**Our ref:** WA/2024/131010/01-L01  
**Your ref:** 23/03231/F  
**Date:** 25 January 2024

### **Erection Of Agricultural Barn For Animal Food Storage, Animal Welfare, Farm Machinery Storage And Security**

#### **Hawthorn Hart Land Wroxton Lane Horley OX15 6BB**

#### **Environment Agency position**

REVISION - 0 DRAWING NO - MT / 1564 / 1

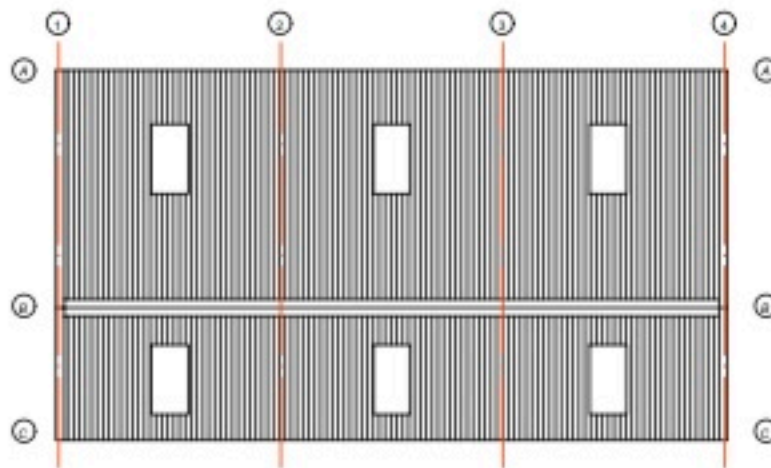
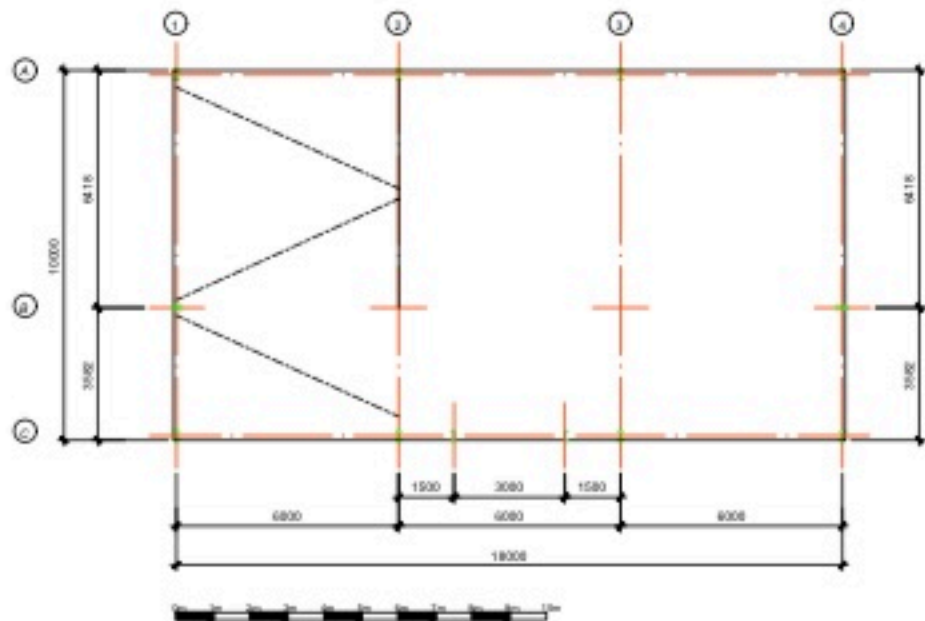
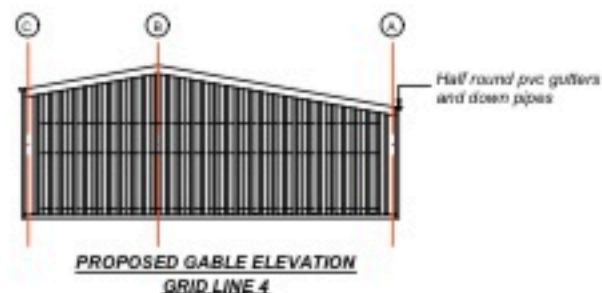
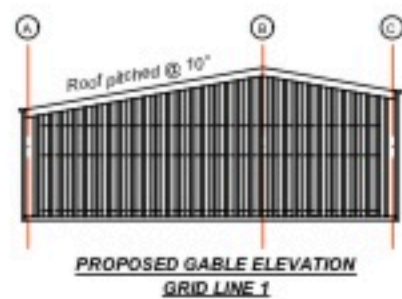
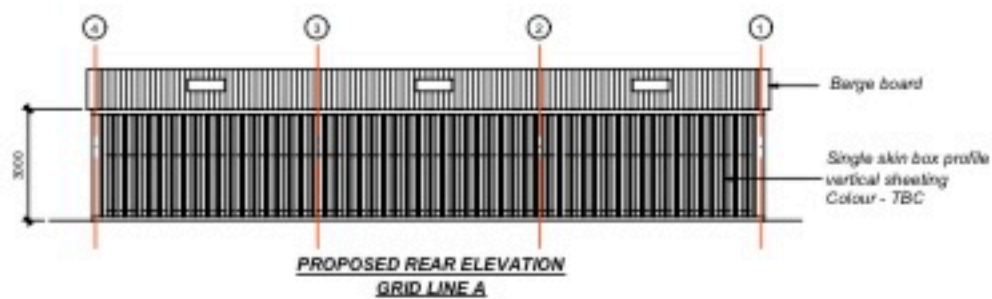
Finished floor levels should be set above the 1% AEP flood level with an appropriate allowance for climate change to reduce the risk of flooding to property and future occupants. We recommend that finished floor levels are raised at least 300mm above this level. This will reduce the risk of flooding to people and property.

Any increase in built footprint or raising of ground levels should be compensated up to the 1% AEP plus an appropriate allowance for climate change flood level. This is necessary to prevent the proposed development reducing floodplain storage and displacing flood waters, thereby increasing flood risk elsewhere.
